CITY OF ALBUQUERQUE

Re: San Mateo Manor
513 Ortiz Dr. SE Albuquerque, NM 87108
Traffic Circulation Layout
Engineer's Stamp 10-16-25 (L18-D088)

Based upon the information provided in your submittal received 10-10-25, the above referenced plan cannot be approved for Building Permit until the following comments are addressed:

6 BIKE RACK DETAIL

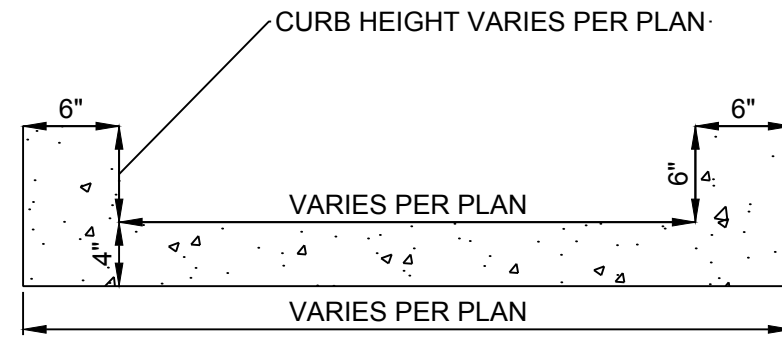
23. Bicycle parking spaces shall be located, sized, and constructed as required by IDO.
24. Provide bicycle parking design. Bicycle racks shall be designed according to the following guidelines:
 - The rack shall be a minimum 30 inches tall and 18 inches wide.
 - The bicycle frame shall be supported horizontally at two or more places. Comb/toaster racks are not allowed.
 - The rack shall be designed to support the bicycle in an upright position. See the IDO for additional information.
 - The rack allows varying bicycle frame sizes and styles to be attached.
 - The user is not required to lift the bicycle onto the bicycle rack.
 - Each bicycle parking space is accessible without moving another bicycle.
25. Bicycle racks shall be sturdy and anchored to a concrete pad.
26. A 1-foot clear zone around the bicycle parking stall shall be provided.

27. Bicycle parking spaces shall be at least 6 feet long and 2 feet wide.

CDS PROJ. NO. **0760225**
 OTHER PROJ. NO.
 SHEET NO: **C-101**

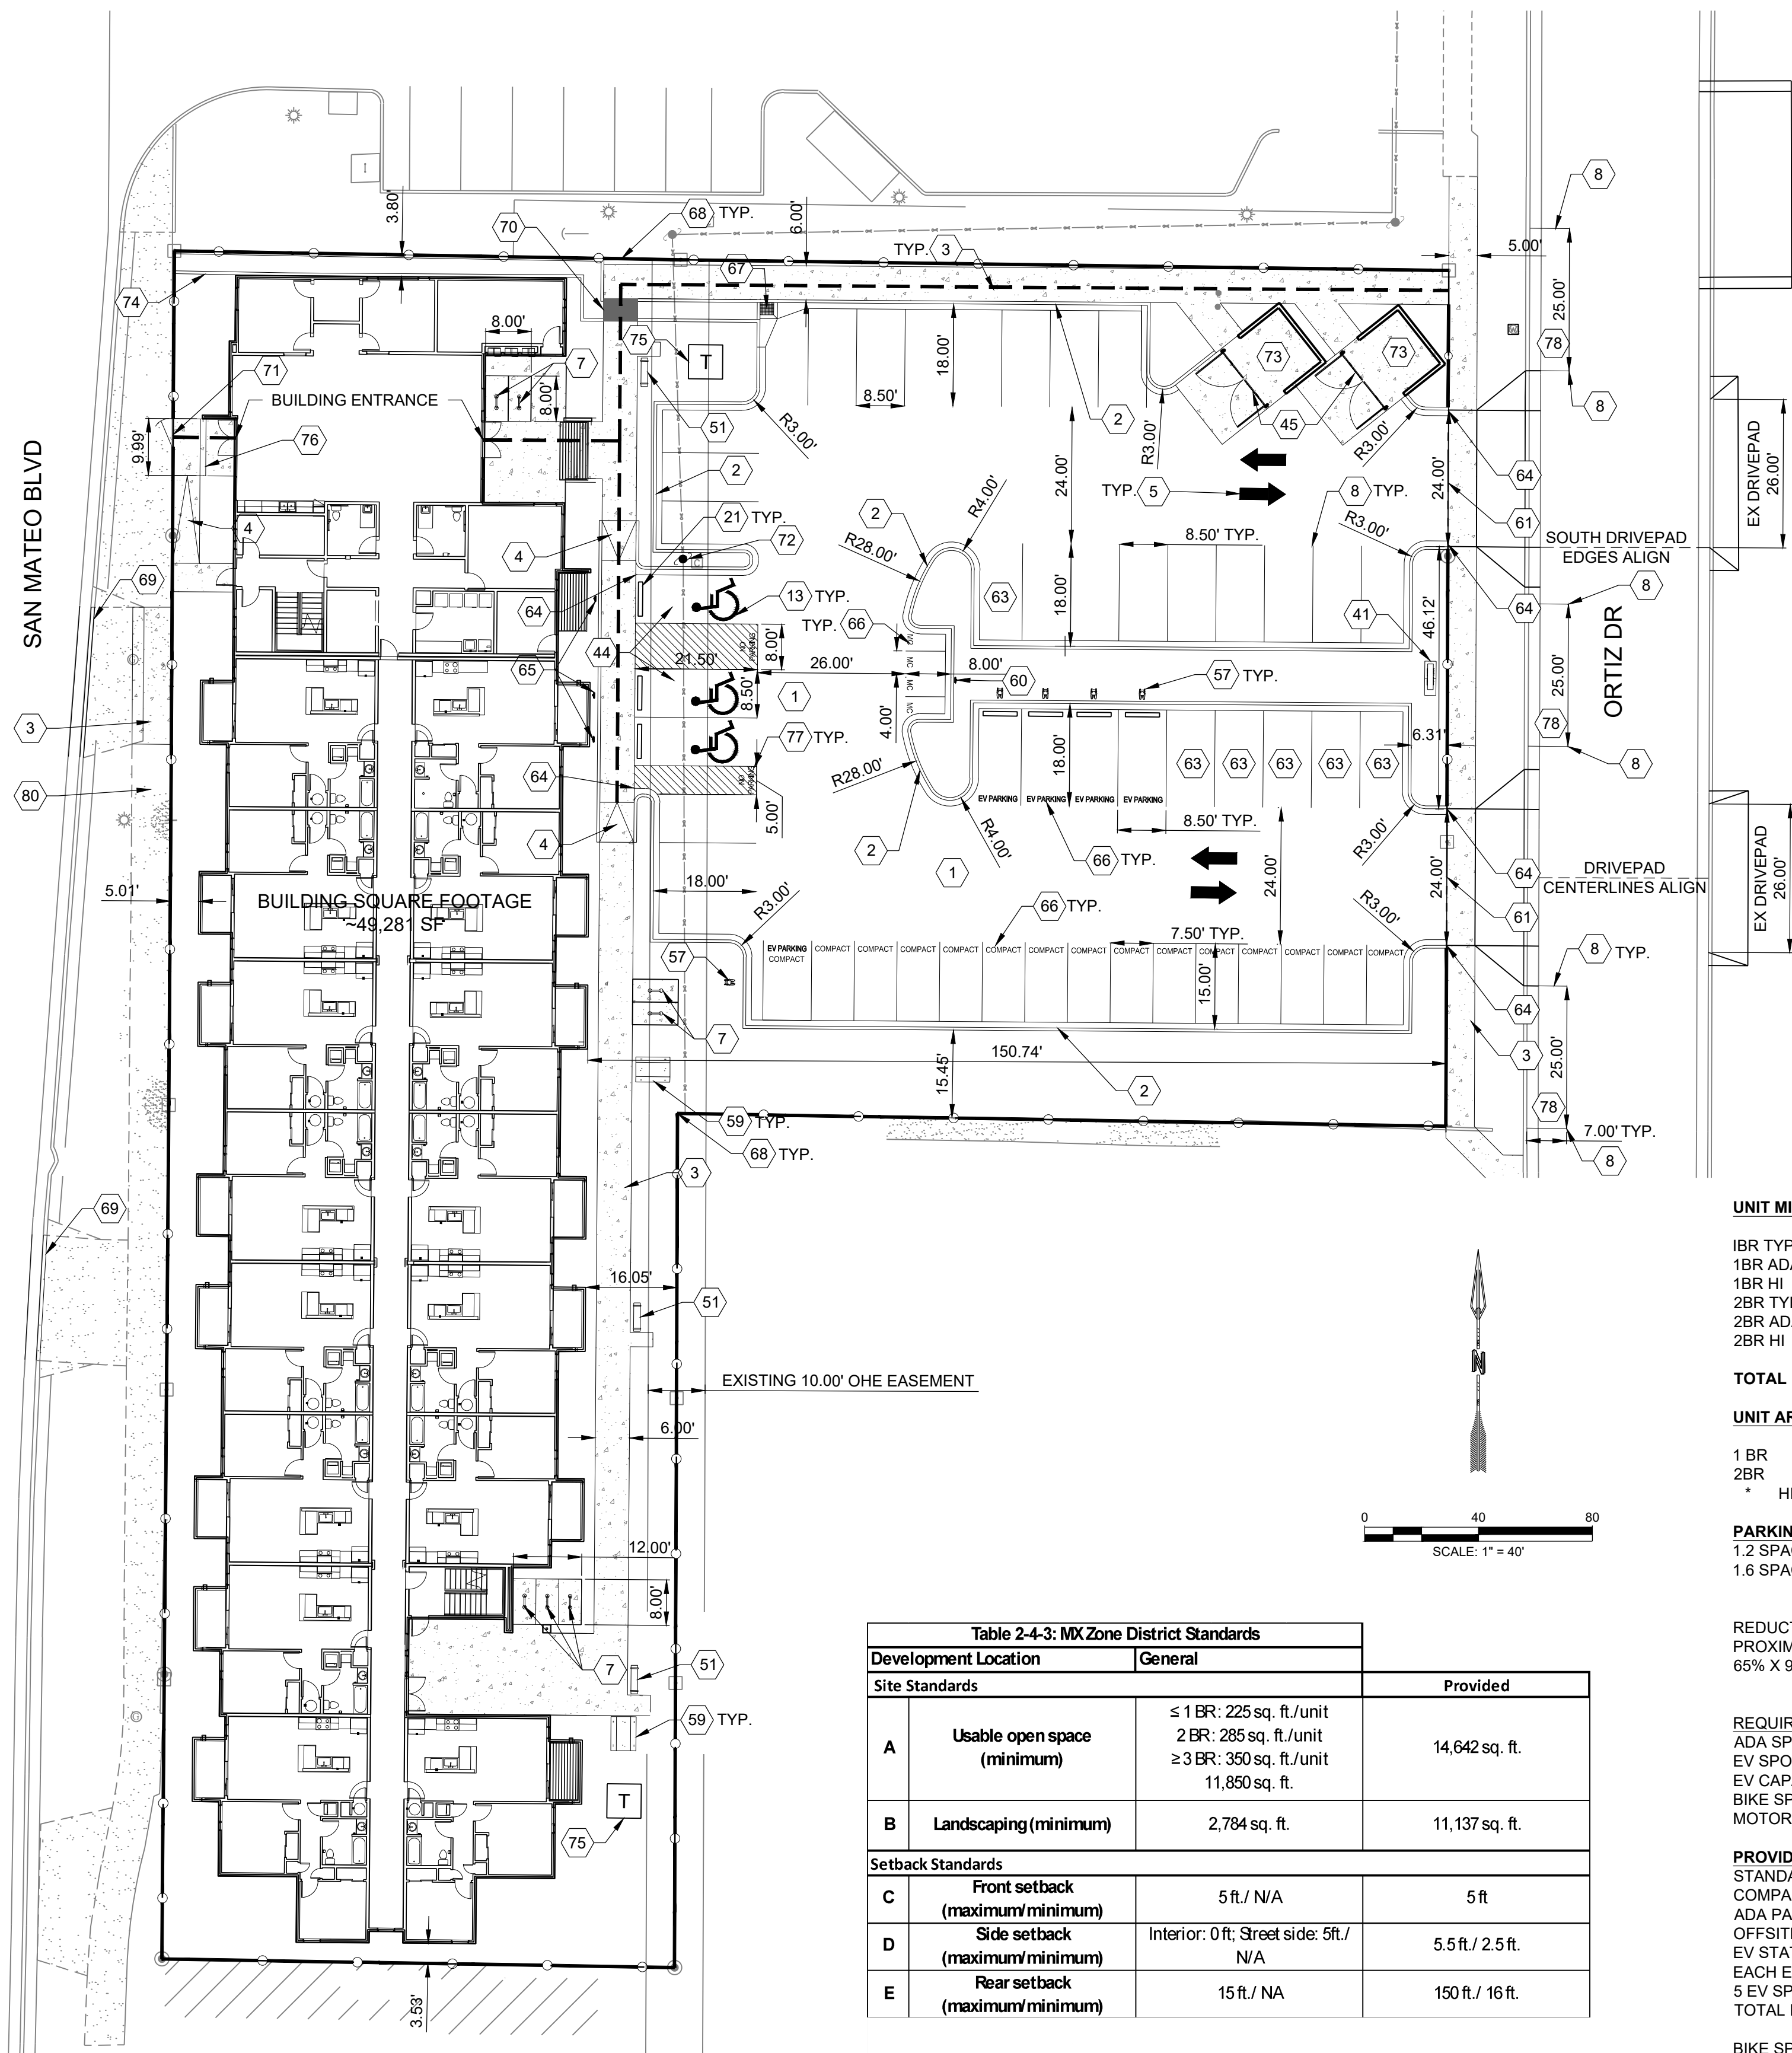
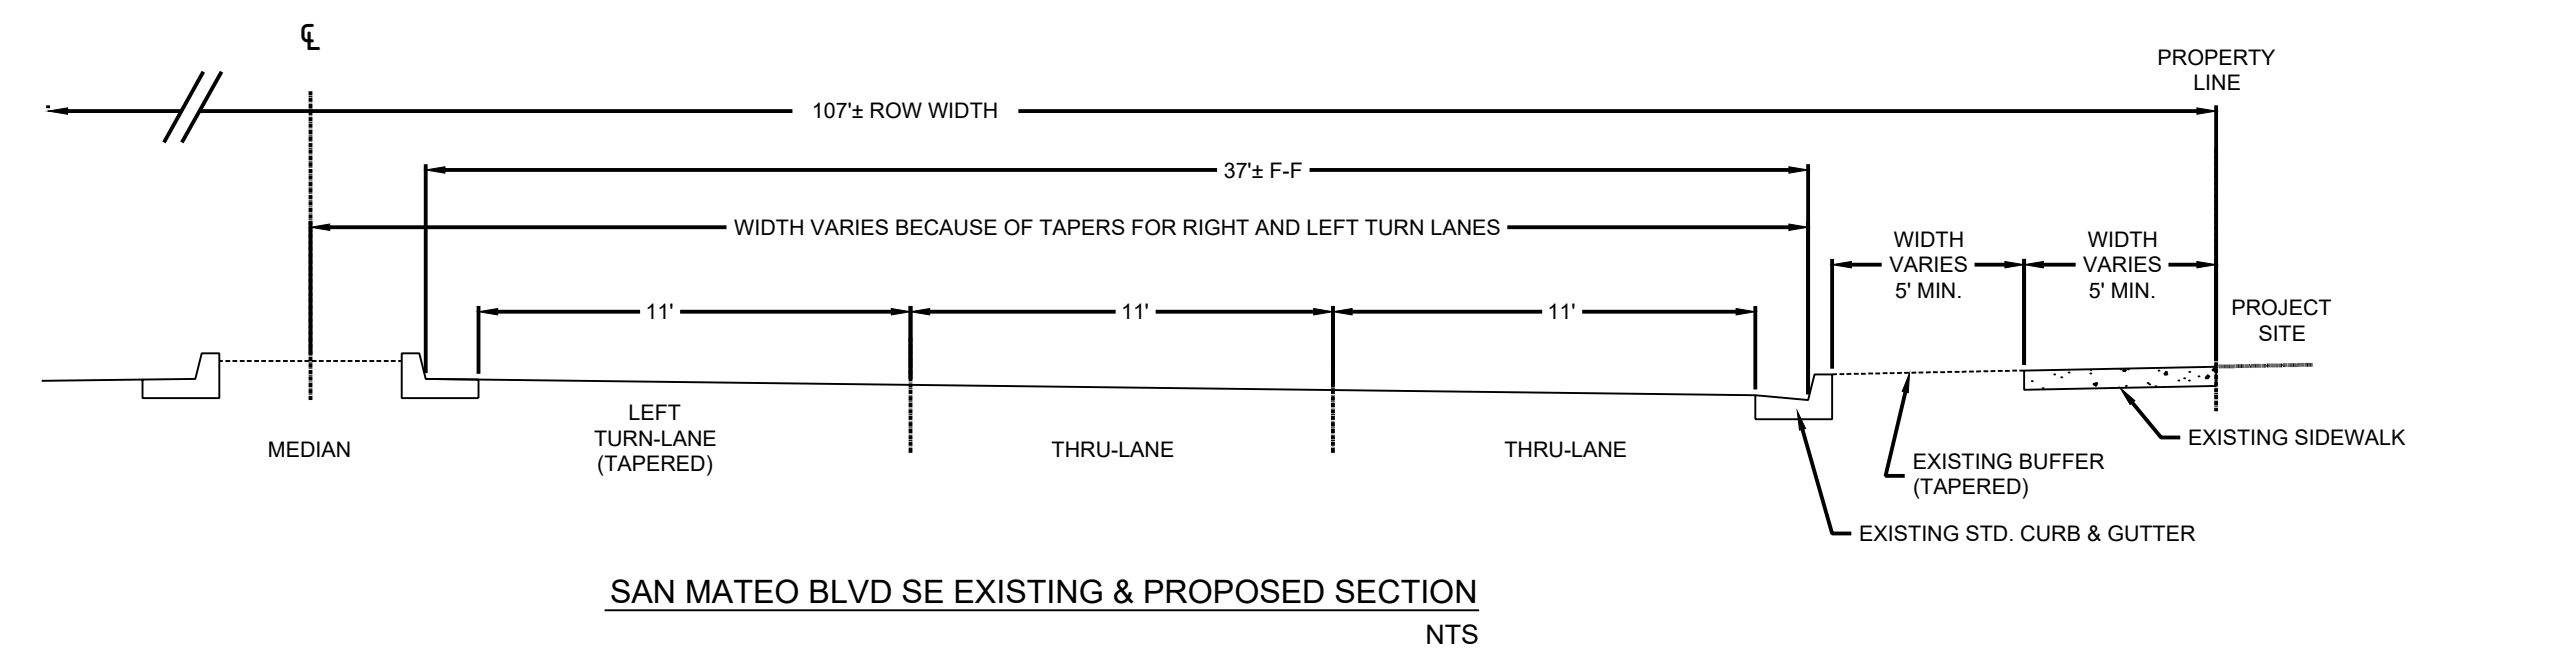
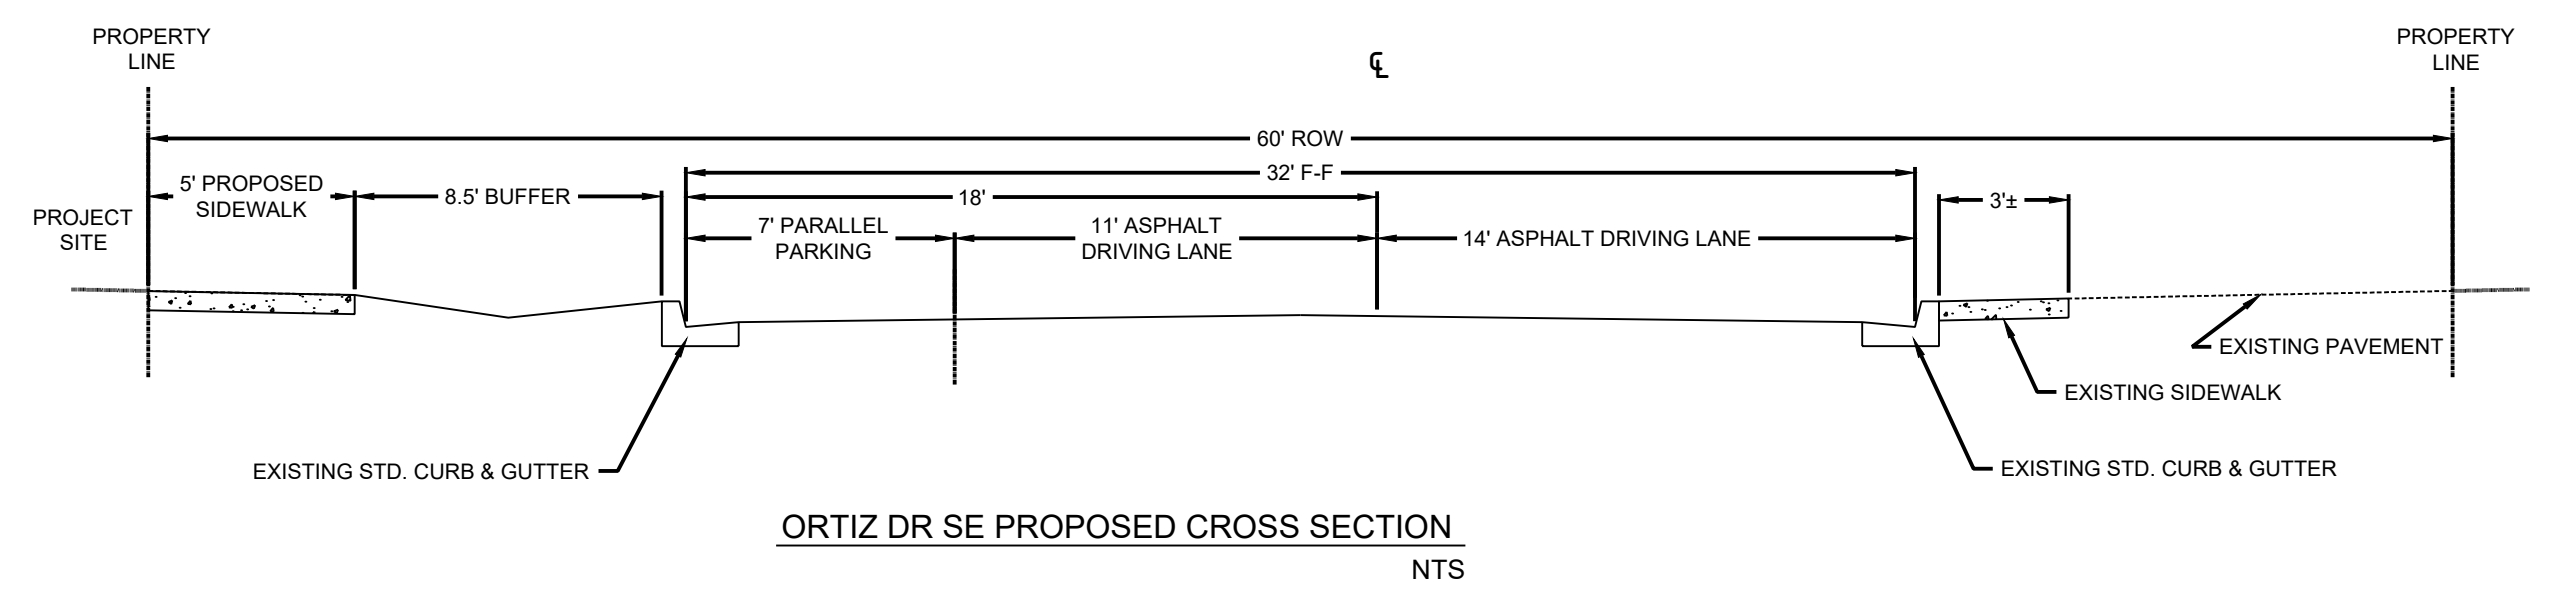
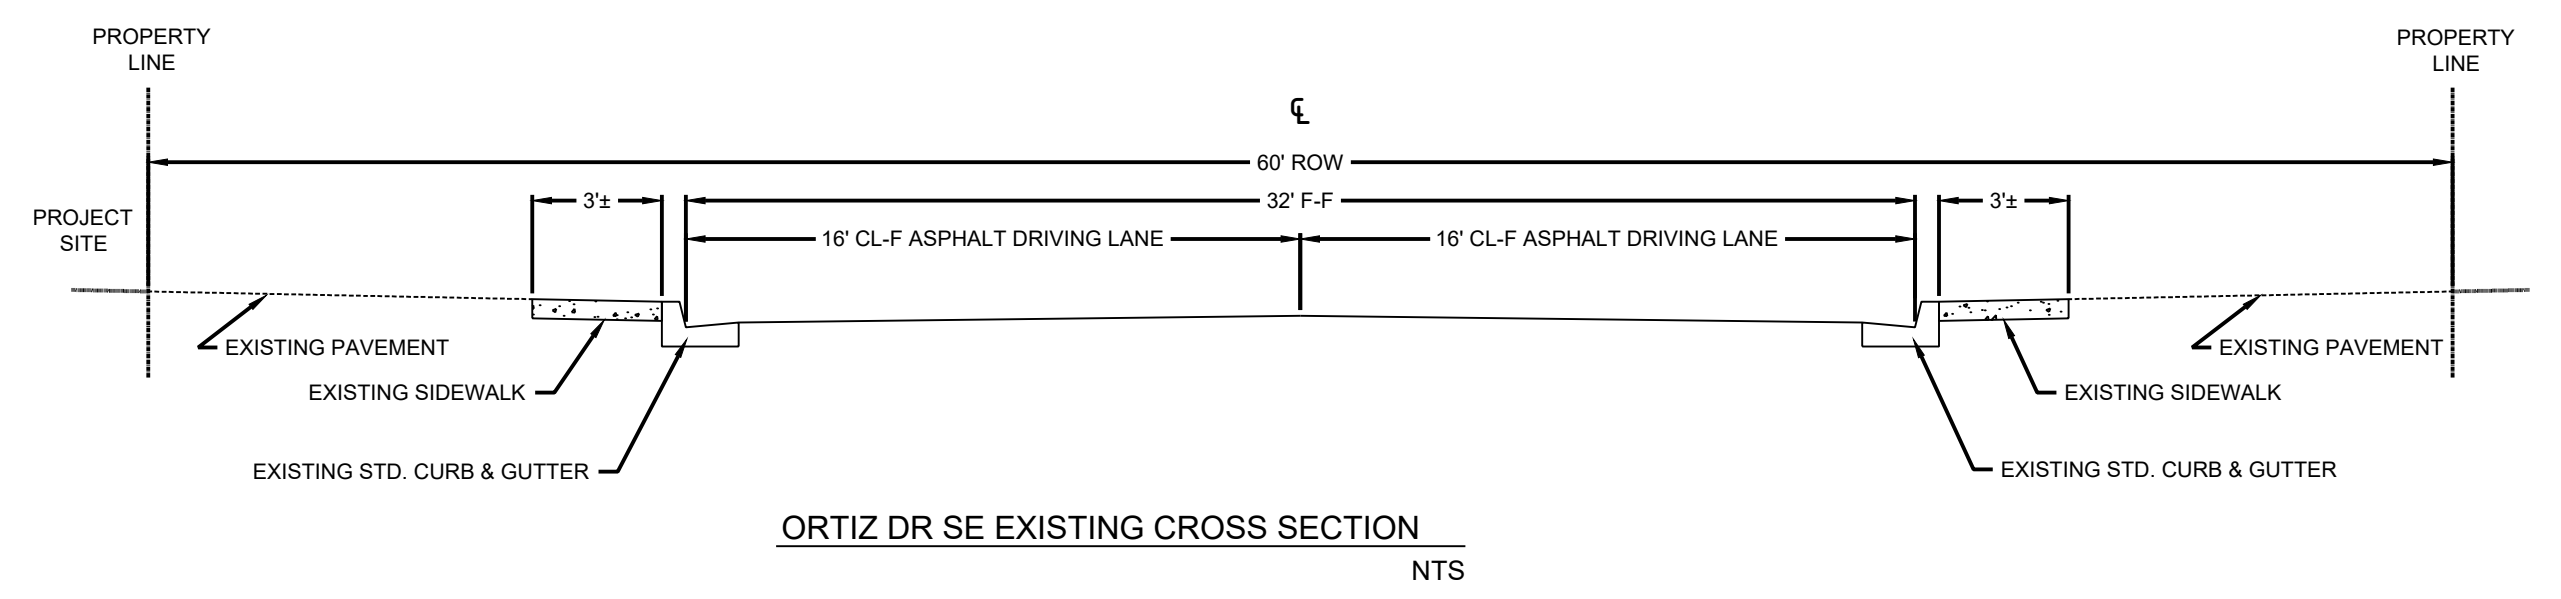
3. Clarify the extents of the current phase. Provide a phasing plan.
4. Identify the right of way width, medians, curb cuts, and street widths on San Mateo Blvd. SE and Ortiz Dr. SE.

5. Identify all existing access easements and rights of way width dimensions.
6. It appears the intentions are to close both driveway access on San Mateo Blvd. Unused curb cuts must be replaced with sidewalk and curb & gutter. Provide design details and applicable City standard drawings.

7. Show existing driveways on the adjacent properties and properties across the street from the site on Ortiz Dr. SE. Provide distancing from these existing driveways to nearby proposed site accessways.

8. Please provide a sight distance exhibit.
9. Show the clear sight triangle and add the following note to the plan: "Landscaping and signage will not interfere with clear sight requirements. Therefore, signs, walls, trees, and shrubbery between 3 and 8 feet tall (as measured from the gutter pan) will not be acceptable in the clear sight triangle.

10. Call out distance/width between proposed driveways.
11. Provide southern proposed drive aisle width.
12. All accessways to the site from the adjacent roadway shall be ADA-compliant.

14. All sidewalks along streets should be placed at the property line. Provide sidewalk design details and dimensions.
15. Parking spaces cannot be bisected by lot lines.
16. Provide Zoning approval documentation for reduction parking credits and EV accommodations. Verify parking calculations per IDO requirements.
17. Provide all parking signs design details.
18. Provide additional parking striping details. ADA access aisles shall have blue diagonal striping and the words **"NO PARKING"** in capital letters, each of which shall be at least one foot high and at least two inches wide, placed at the rear of the parking space so as to be close to where an adjacent vehicle's rear tire would be placed. (66-1-4.1.B NMSA 1978)

19. We notice the 4.5 foot ADA parking access aisle. Van access aisles must be a minimum 8 feet wide and all others must be a minimum 5 feet wide. Provide dimensions for each ADA stall and access aisles.

20. Per the DPM, a 6 ft. wide ADA accessible pedestrian pathway is **required from the public sidewalk to the building entrances**. Clearly show this pathway and provide details. Also, call out building entrance.

21. Per DPM, a 6 ft. wide ADA accessible pedestrian pathway is **required from the ADA parking stall access aisles to the building entrances**. Please clearly show this pathway and provide details.

22. Call out on-street parking spaces and provide design details meeting City standards. On-street parking spaces shall be designed according to the following guidelines:

28. Provide motorcycle parking space dimensions.

29. Provide motorcycle pavement marking "MC" for each motorcycle parking space.

30. Refuse vehicle maneuvering shall be contained on-site. The refuse vehicle shall not back into the public right of way.

34. Provide additional site circulation details. Are site access ways to function for two way flow or one way?

35. Driveway access must meet current City and ADA standards. Where the aisles will function for deliveries by larger trucks, refuse, and/or fire vehicles, etc., a 25 foot radius or larger is to be used. Provide City standard drawings that reflect design intentions.
